Comments on Modification 3 to Narrabri Coal Seam Gas Utilisation Project (MP 07\_0023)  
as submitted by Santos.

Jessie Gibley,  
Planning Officer,  
NSW Department of Planning and Infrastructure.

22<sup>nd</sup> December 2013

Figure 3-1 Proposed riser schematic

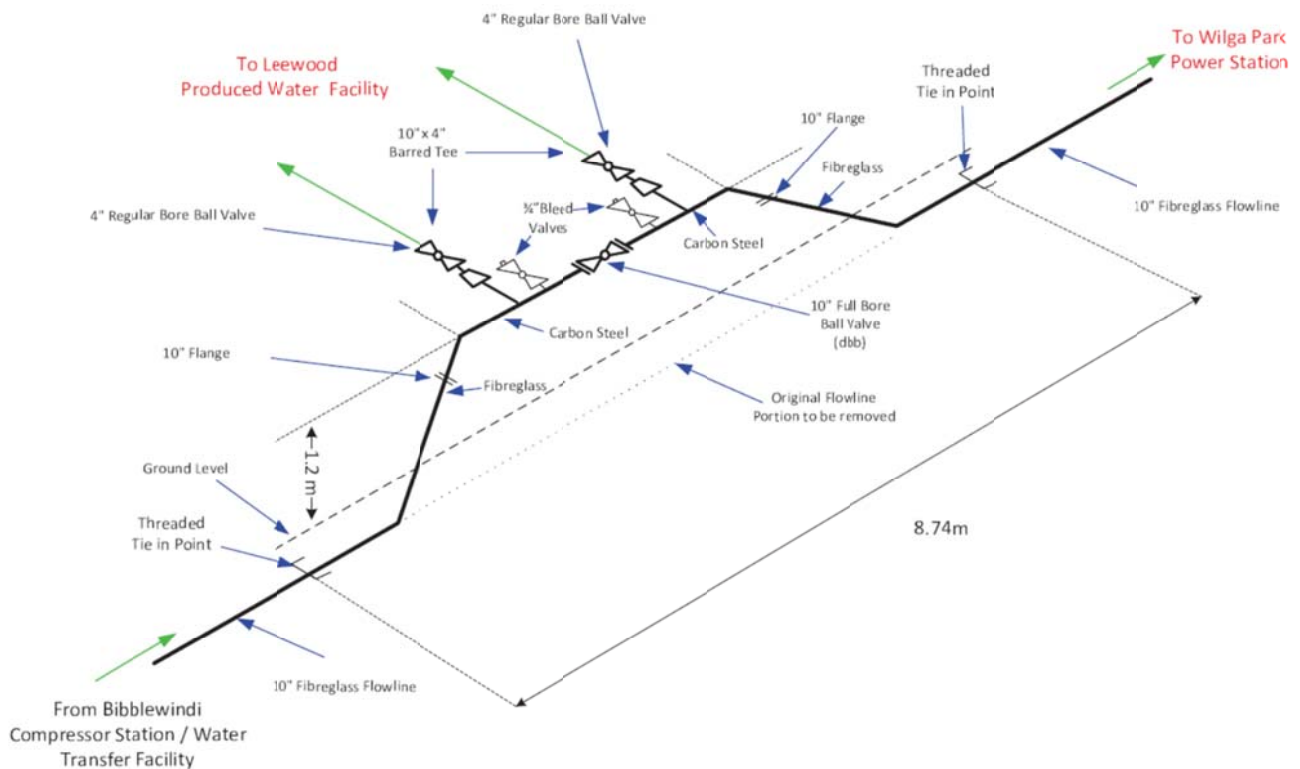
I have some concerns with the dissimilar metals used on the 'riser' at Leewood and what could be the result should corrosion not be seen and addressed (specifically the ability from galvanic action to occur between the various different metal components of the riser and valving). As stated this riser will, from time to time be subjected to a fluid that has the properties and capability of being an electrolyte (produced water and storage pond concentrated water), so what measures and inspections will be undertaken to ensure that there will be no possible accidents due to natural dissimilar metal reaction.

Then there is the material of the *"Temporary above-ground pipes, pumps and fittings that would be connected to the riser"* as well as the pump seals. What is the construction material, how will these stand up to the fluids that they are being exposed to and how long is temporary, what preventative measures are in place and are they sufficient?

This concern is raised based on Corrosion Technology.
